CITY OF ALBUQUERQUE

December 13, 2018

**RE: Harper Senior Living
Grading and Drainage Plan
Engineer's Stamp Date: 11/16/18
Hydrology File: E20D020B**

Based upon the information provided in your submittal received 11/16/2018, the Conceptual Grading Plan and Drainage Report **is not** approved for action by the DRB for Site Plan for Building Permit. The following comments need to be addressed for approval of the above referenced project:

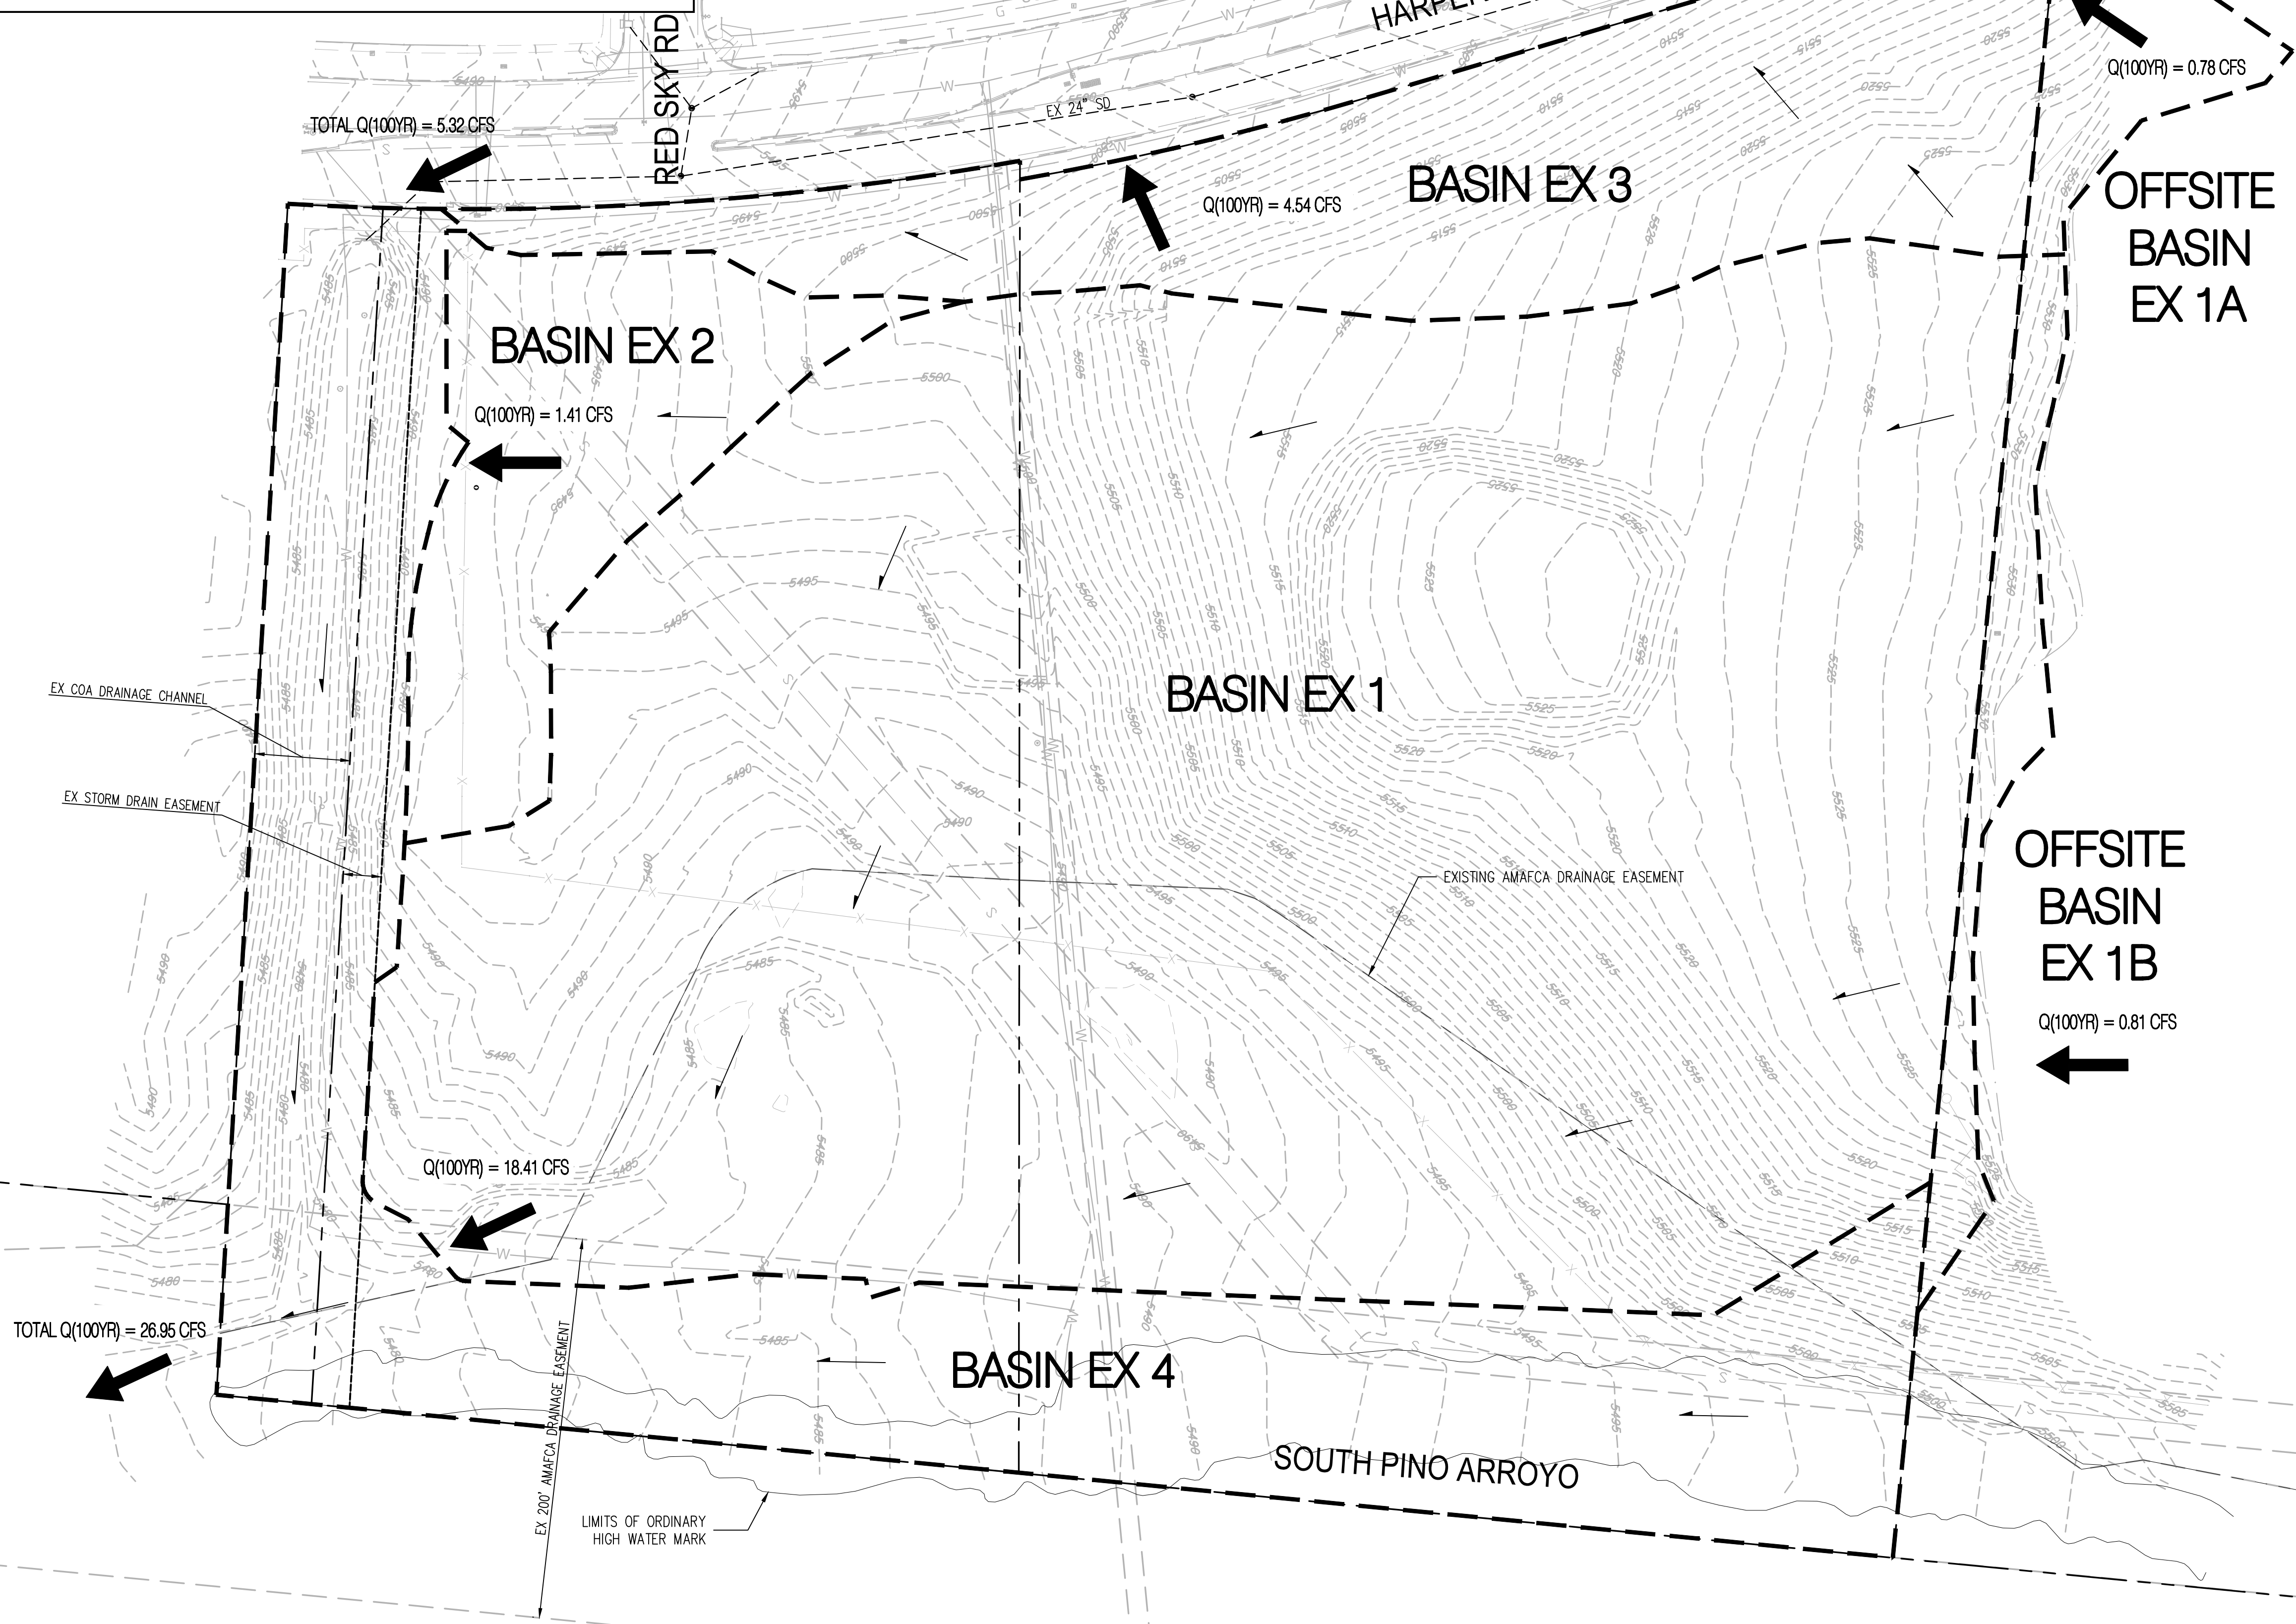
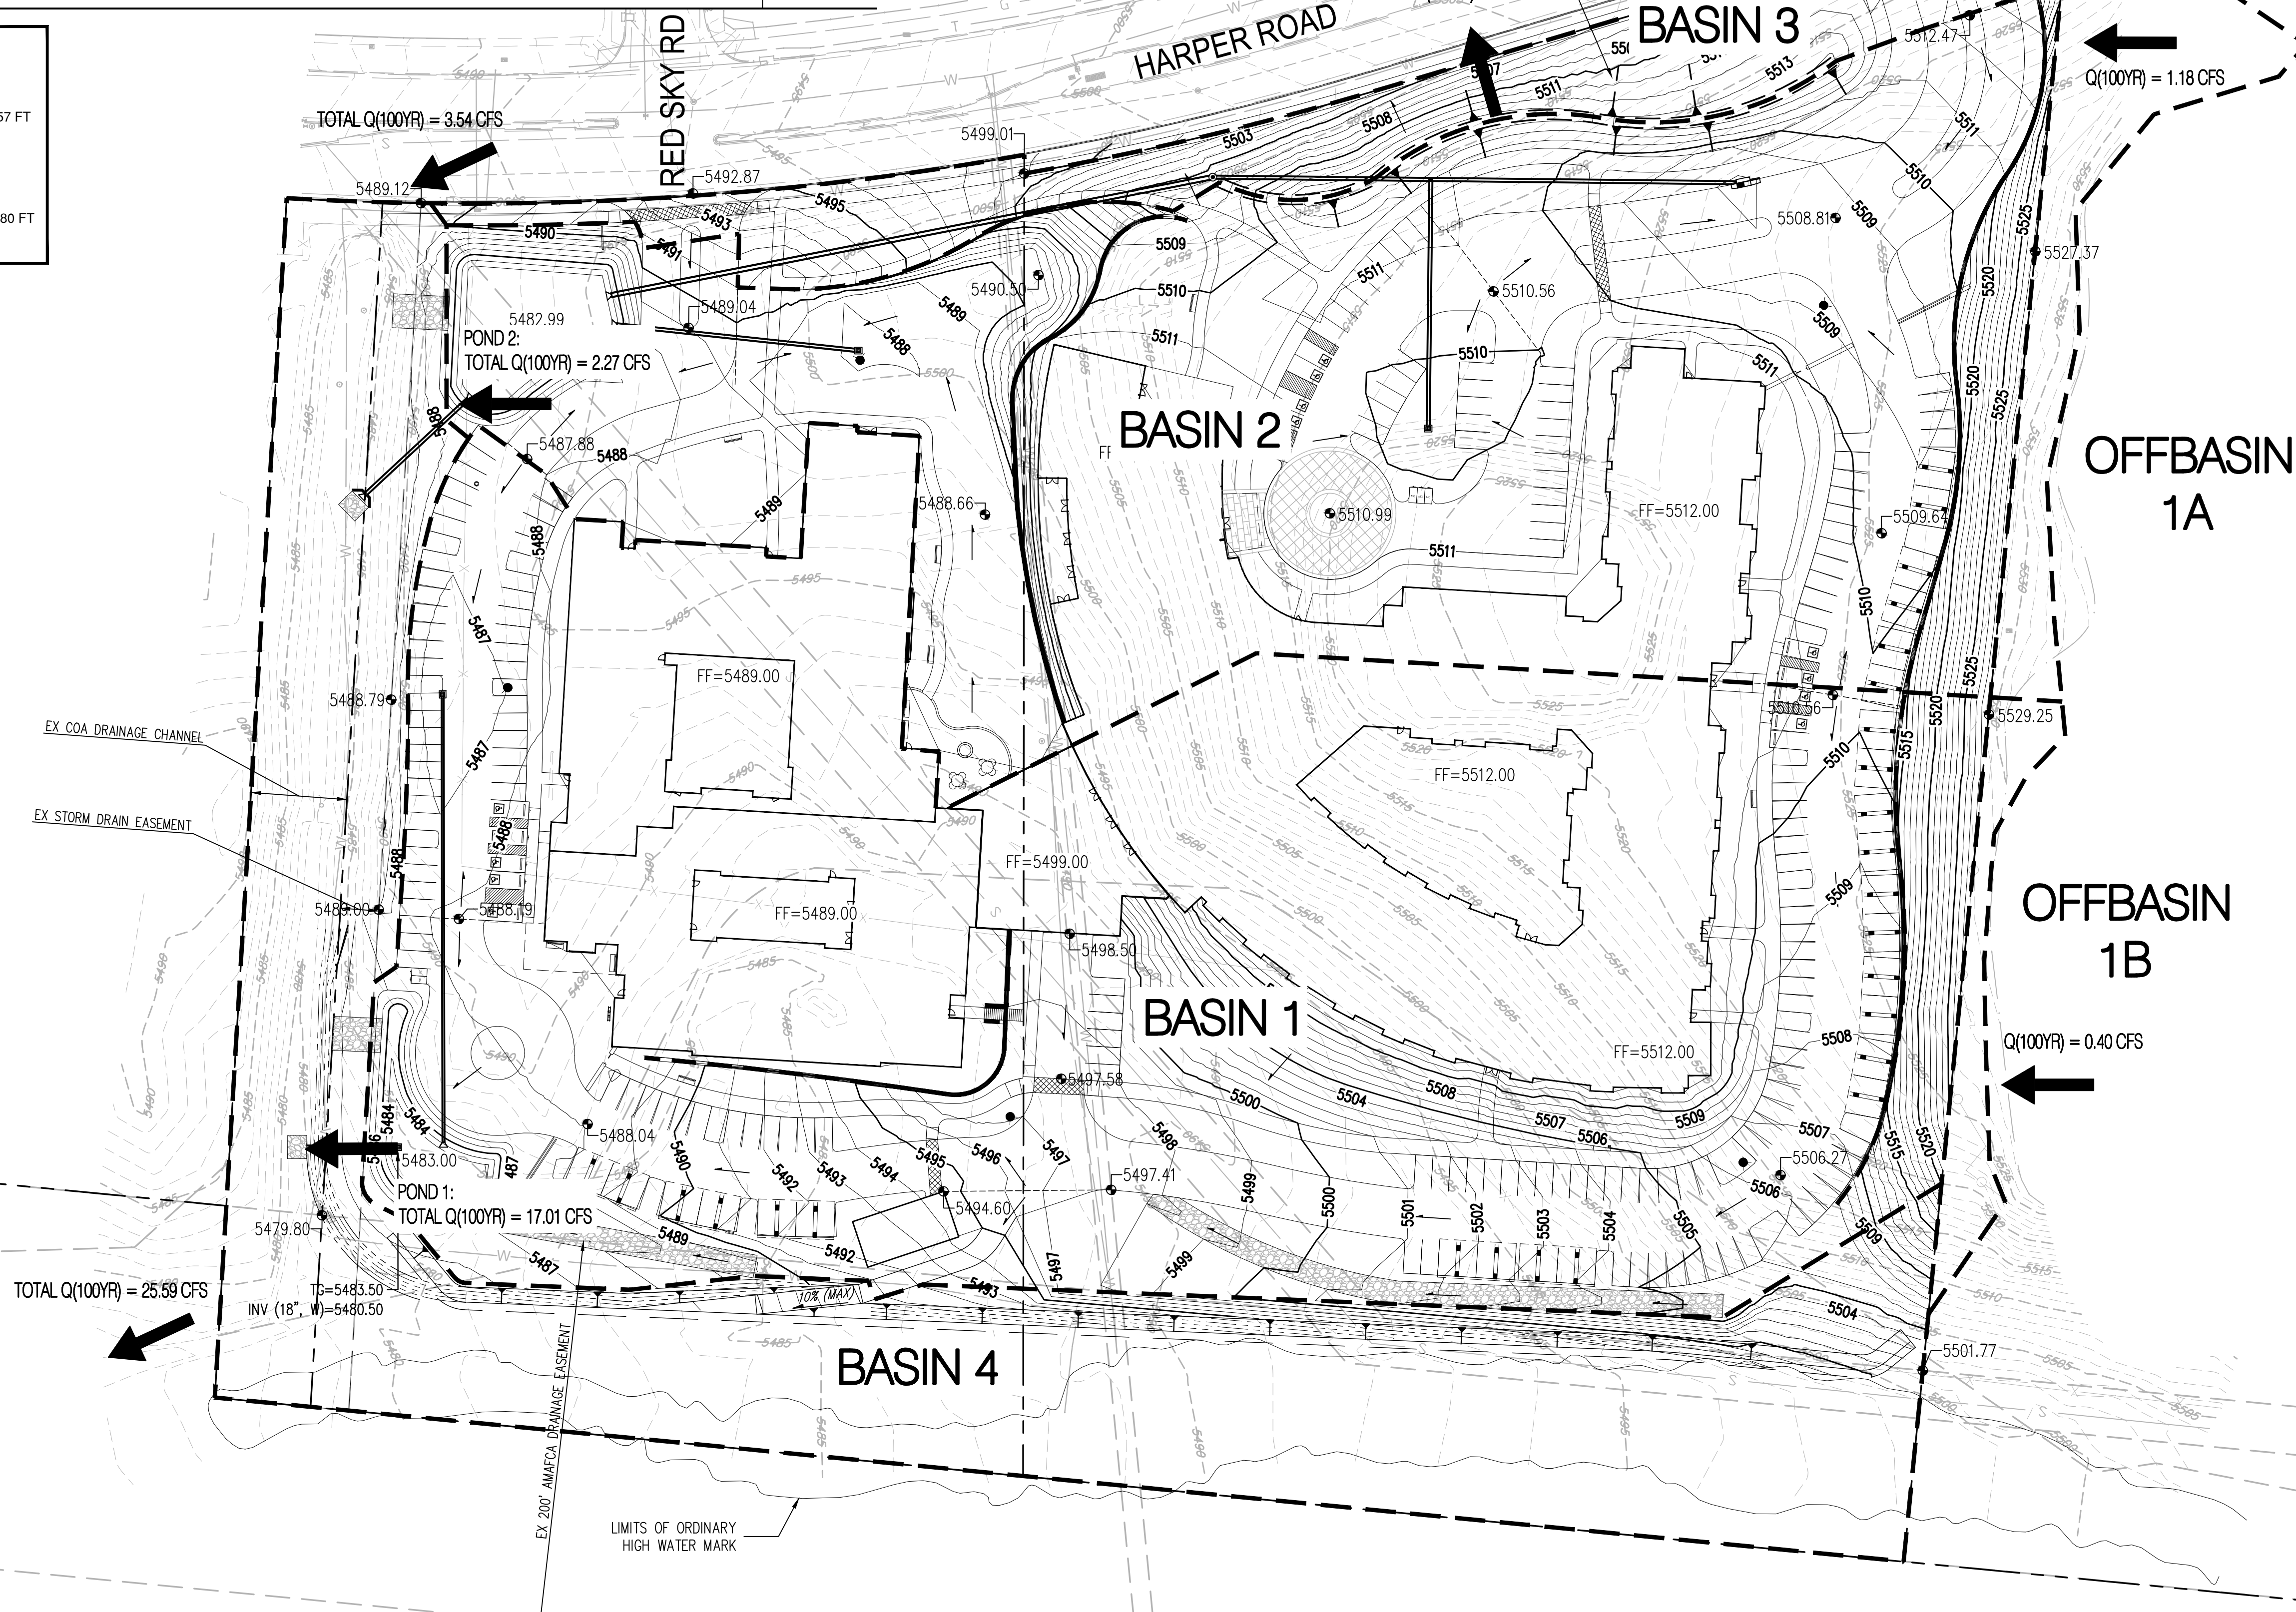
14. Sheet C-001 & C-002. Please verify the off-site drainage basins. When reviewing the approved plans and aerial of the adjacent church, it appears that the drainage basins could be reduced and/or the drainage basin discharges directly to Harper Road instead of onto this site. Also please make the off-site drainage basins the same on both Sheets.
